Location: 70 Mellor Brow Mellor BB2 7EX
Proposal: Proposed alterations to front boundary retaining wall including repointing, increase in height, new copings, steel railings along the top of wall and removal of existing hedge.
Grid Ref: 364744 431015

Lancashire County Council acting as the Local Highway Authority (LHA) does not consider that the application as submitted fully assesses the highway impact of the proposed development and further information is required as set out in this response.

**Plan of Wall - Proposed**

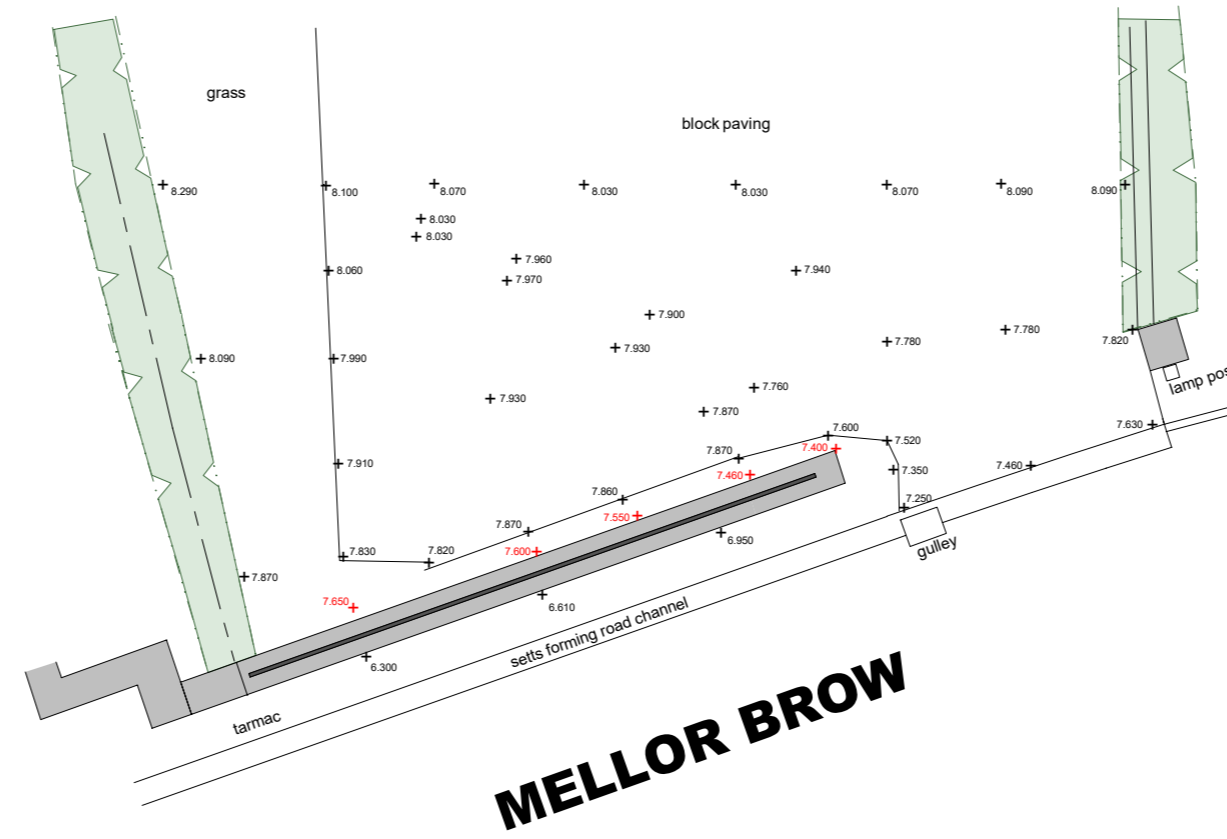
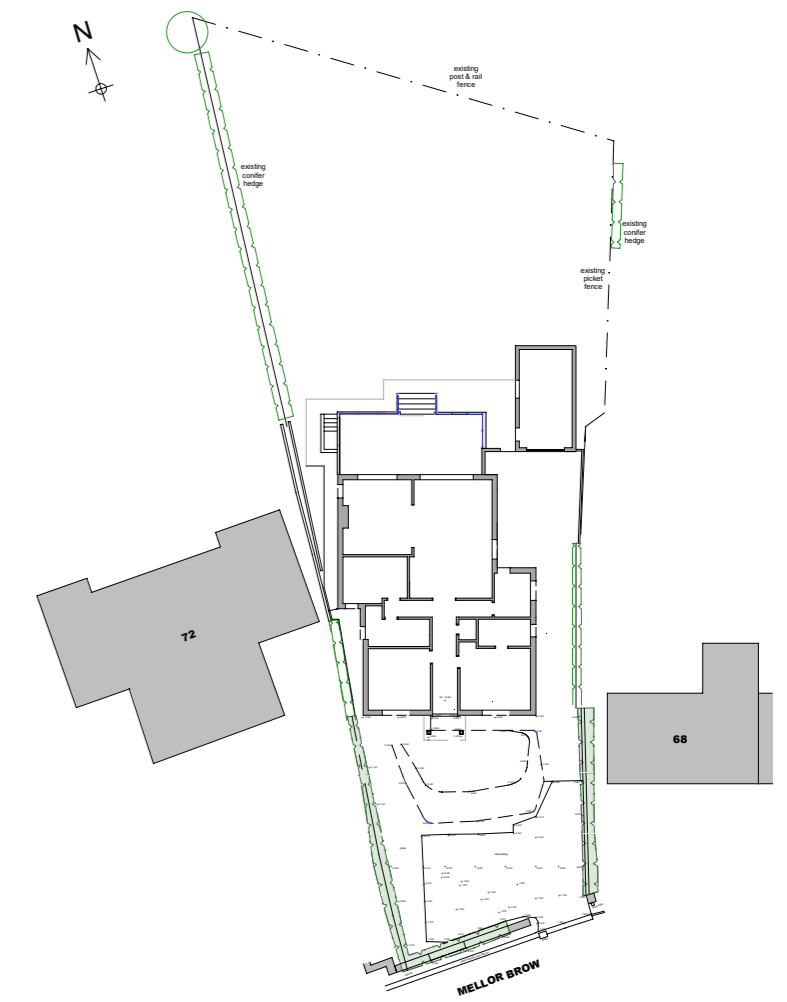
The LHA has reviewed the proposed plans and elevations and has some concerns regarding the proposal's impact on the visibility of the applicant's driveway. The access appears to have made use of a traffic mirror pointed in the direction of the wall which forms part of the proposal which indicates that there has already been concerns over visibility at this location.

The applicant could also provide a visibility splay drawing at the access which would provide a clear picture of if and how much of the wall falls within the access's visibility.

The visibility splay shall be based on the posted speed limit of 30mph in line with Table 7.1 of Manual for Streets. The splay should be set back 2.4 metres from the centre of the access and extending 43 metres along the nearside carriageway edge.

In summary, the applicant should consider reducing the wall height to no more than 1m above the carriageway level or provide a visibility splay drawing set back 2.4 metres from the centre of the access and extending 43 metres along the nearside carriageway edge, anything which falls within the visibility splay will need to be no higher than 1m above the carriageway level.

**Elevation from Roadway - Proposed**

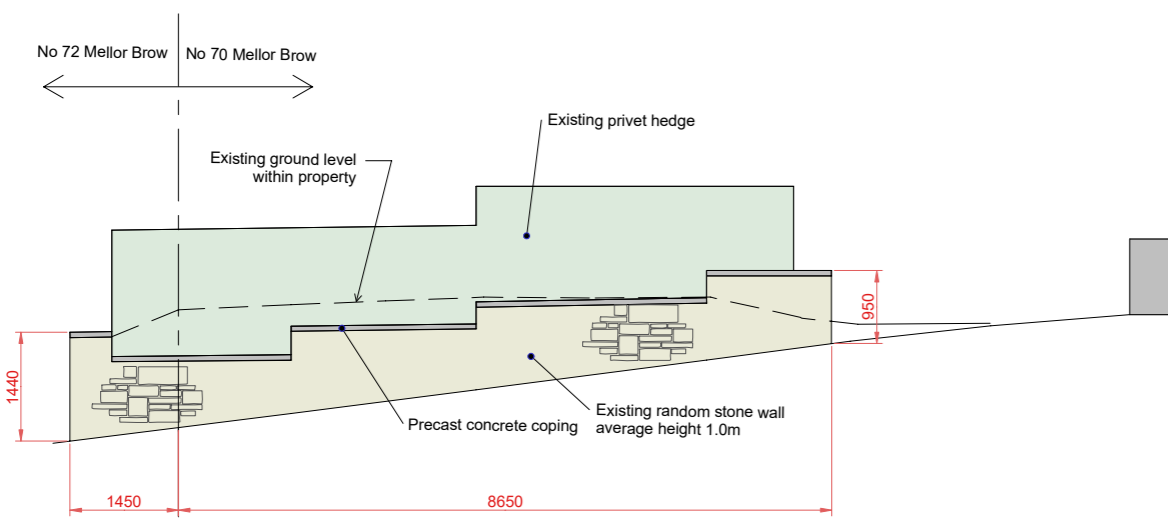
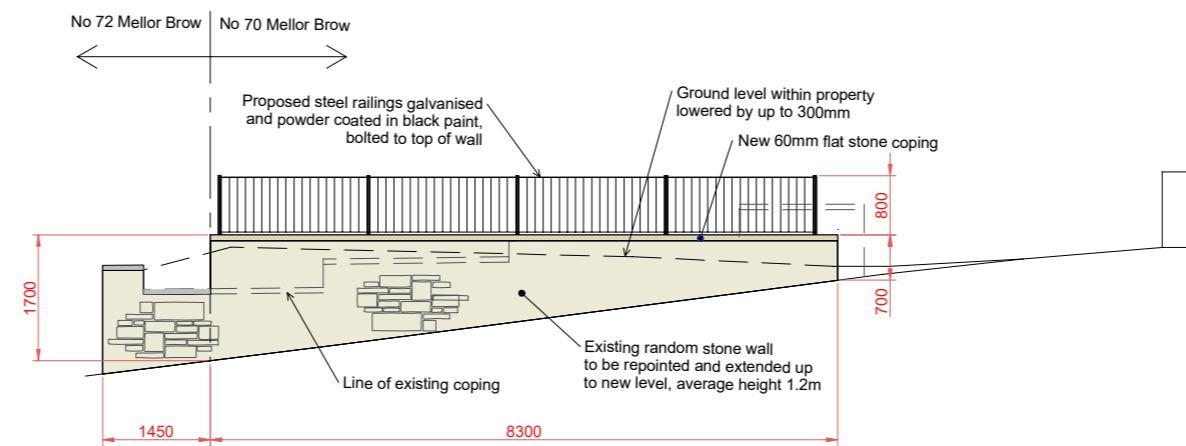
However, there are concerns over increasing the height of the wall which includes a section which sit 1.7m above the carriageway level, given the height of the existing wall the LHA would accept the wall being replaced to 1m in height above the carriageway level

however to optimise visibility the LHA would advise that the wall to be no higher than 0.9m above the carriageway level.
